Your Ref: OWQC25388
Our Ref: EP/157/19/HH
Please ask for:
Mr Z Denton

7th January 2020

First floor extension and changes to cladding and finishes.
St Briac South Strand East Preston

Project: Proposed extension; St. Briac, South Strand, East Preston BN16 1NY	
Drawing: Elevations as proposed	
For: Mr. J. Trusson & Ms. L. Byrne	
Drawn: PKS	Date: November 2019
Scales: 1:100	No: 2510/01/03
To scale when printed on A3

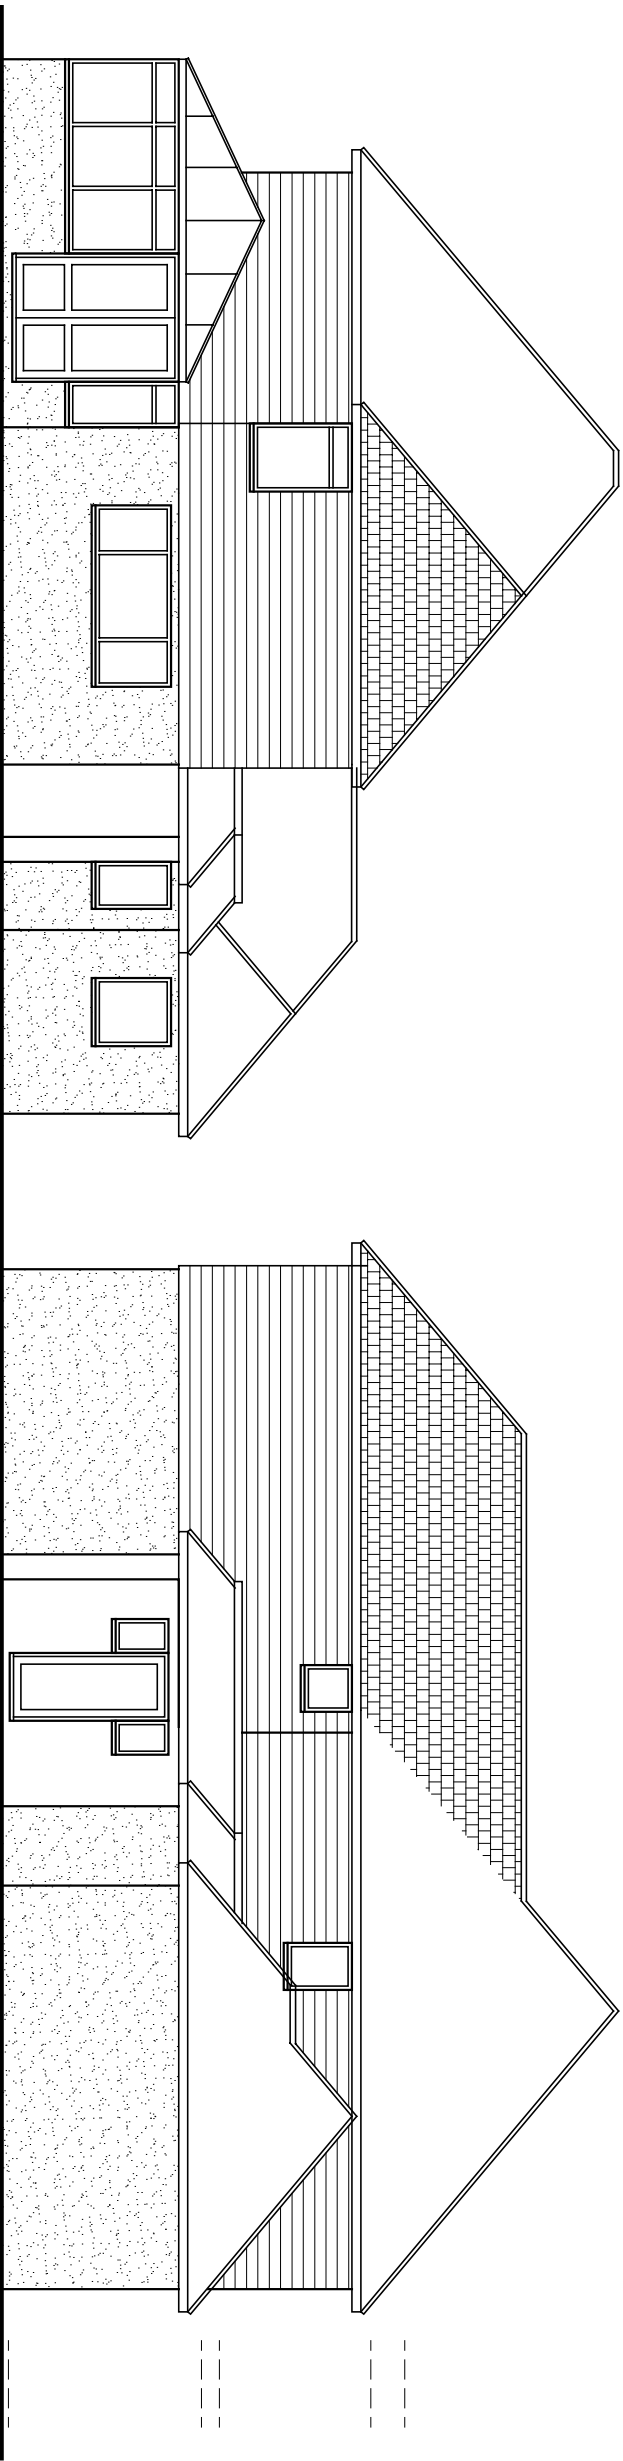
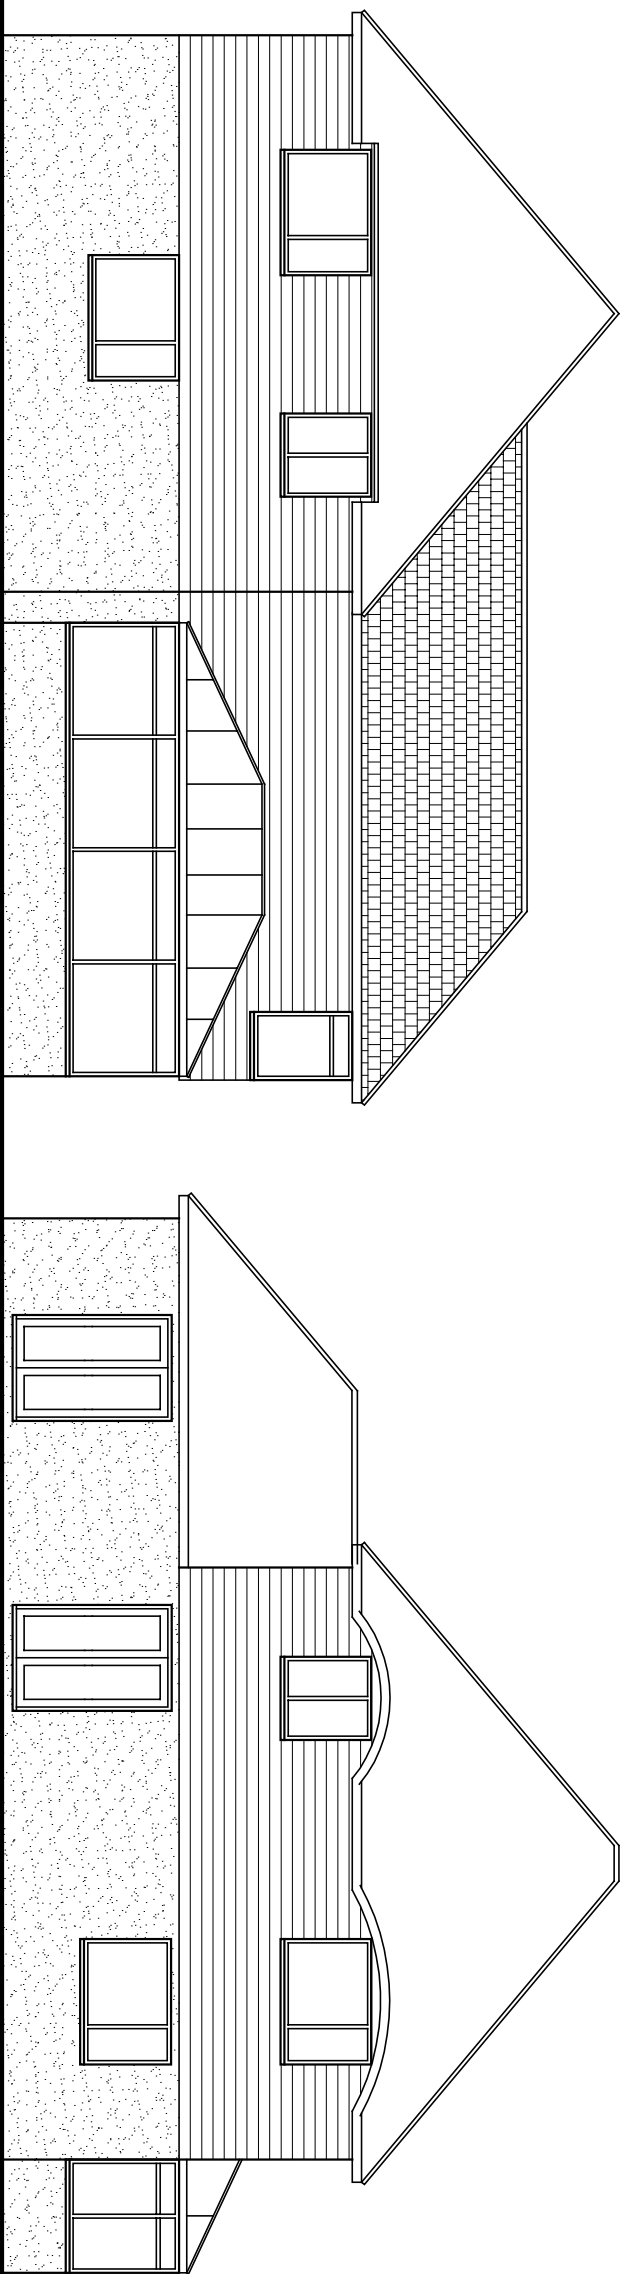
The committee agreed it would object to the proposed materials for this Application. The committee agreed with the East Preston & Kingston Preservation Society in believing the proposed materials would not harmonise with neighbouring properties and would therefore be contrary to Policy D DM1 of the Arun Local Plan. Of particular concern was the proposal to use grey Marley Cedar board and "coloured render" for the walls. The committee was concerned the resulting property would look unnecessarily monochrome, contrary to the vernacular palette of the area.
